RE: ABQ Studios Expansion WO #3 (CPN: 393587)
Drainage Management Plan
Engineer's Stamp Date: 3/8/2023
Hydrology File: R16DA2006

Re: ABQ Studios Expansion WO #3
Drainage Report and Drainage Management Plan Comments
Engineer's Stamp Date: 1/27/2023
Hydrology File: R16DA2006

**ABQ STUDIOS EXPANSION
WORK ORDER PACKAGE 3**

DRAINAGE MANAGEMENT PLAN

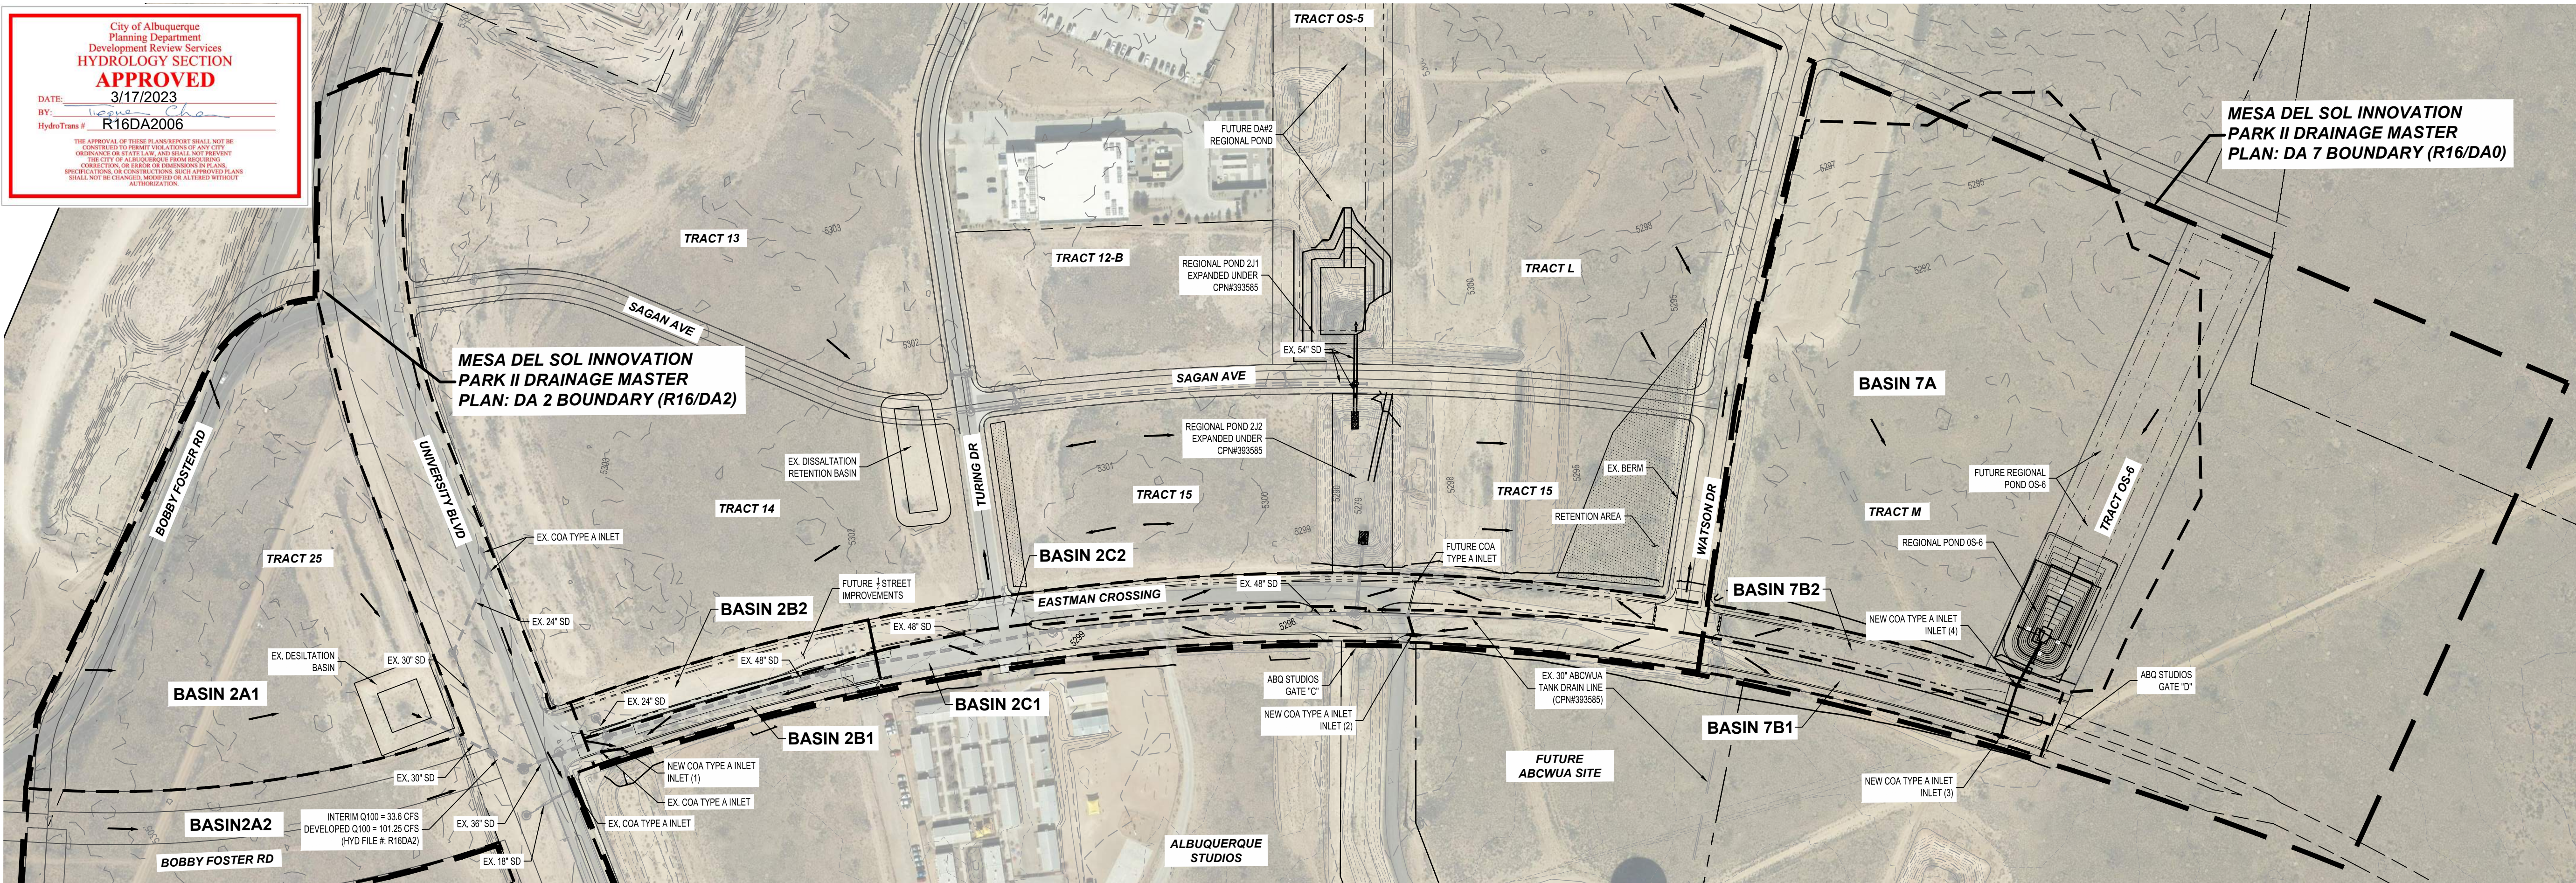
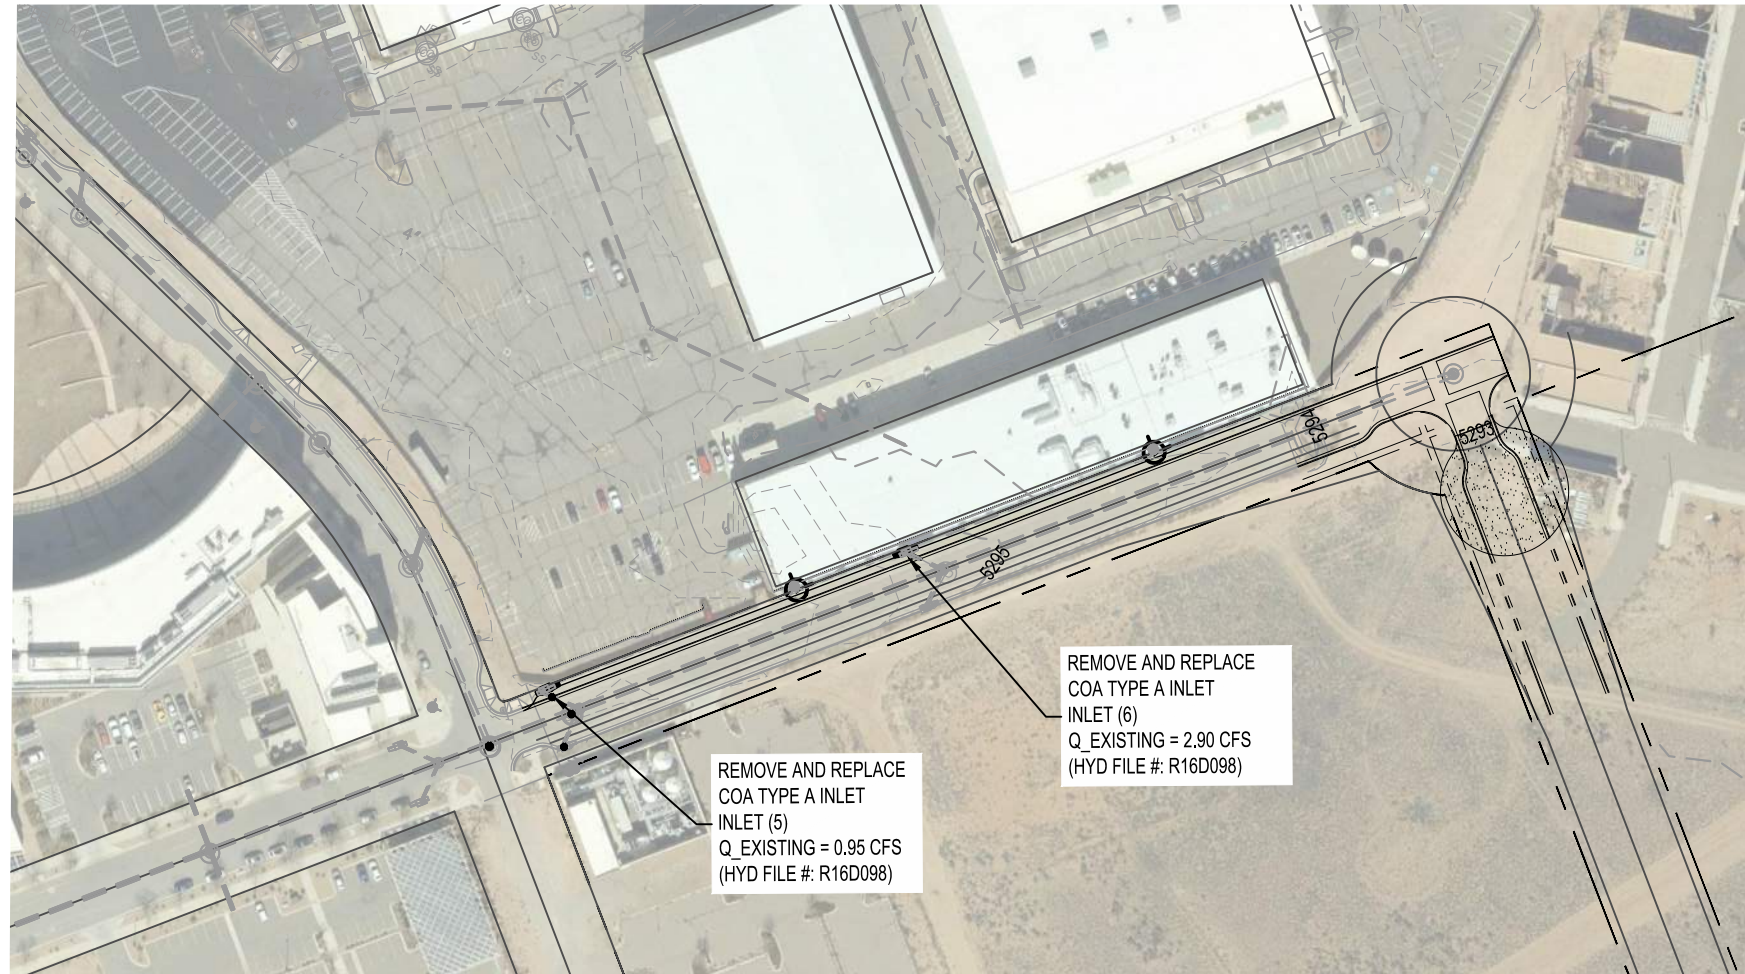
1. **Please add contour elevation labels.**
 - a. Elevation labels added throughout the plan to show elevation references for major contours.
2. **Provide the Benchmark information (location, description and elevation) for the survey contour information provided.**

4. **I couldn't find "Basin 4A1" in the "Existing Conditions", do you mean "basin 2A1"**
 - a. Yes, the updated narrative has been edited to reflect the reference to "Basin 2A1" that aligns with the tables and plan view.

5. **Provide the regional retention pond number located to the south in the "Existing Conditions". Provide drainage calculations showing that this pond have enough volume capacity to accommodate discharge from the Stryker Road.**

6. It'd be easier to read if the Eastman Crossing and Stryker Road plans being placed on to two separate sheets.

- a. Provided. These also correspond to the survey control sheet that was prepared with the CPN #393587 plan set.
3. **Was the drainage report included? I only found the drainage management plan from the file downloading weblink.**

- a. A separate drainage report was not included, as BHI felt the drainage conditions and considerations were accurately and fully represented with the provided Drainage Management Plan.

- a. Pond MDS-OS7, CPN #775684, Hydrology File R16D097A. Calculations were not provided because no additional flows (compared to existing) are being discharged to the pond as a result of this Public Work Order improvements. The proposed changes to the northern curb line of Stryker Road actually decreases the amount of discharge reaching MDS-OS7. See CPN #775684, Hydrology File R16D097A for regional pond analysis.

- a. Understood, however as the improvements to Eastman, University, and Styker are all part of the same COA Public Work Order, we felt that it was most appropriate to have a single Drainage Management Plan that corresponds to the single Public Work Order plan set.
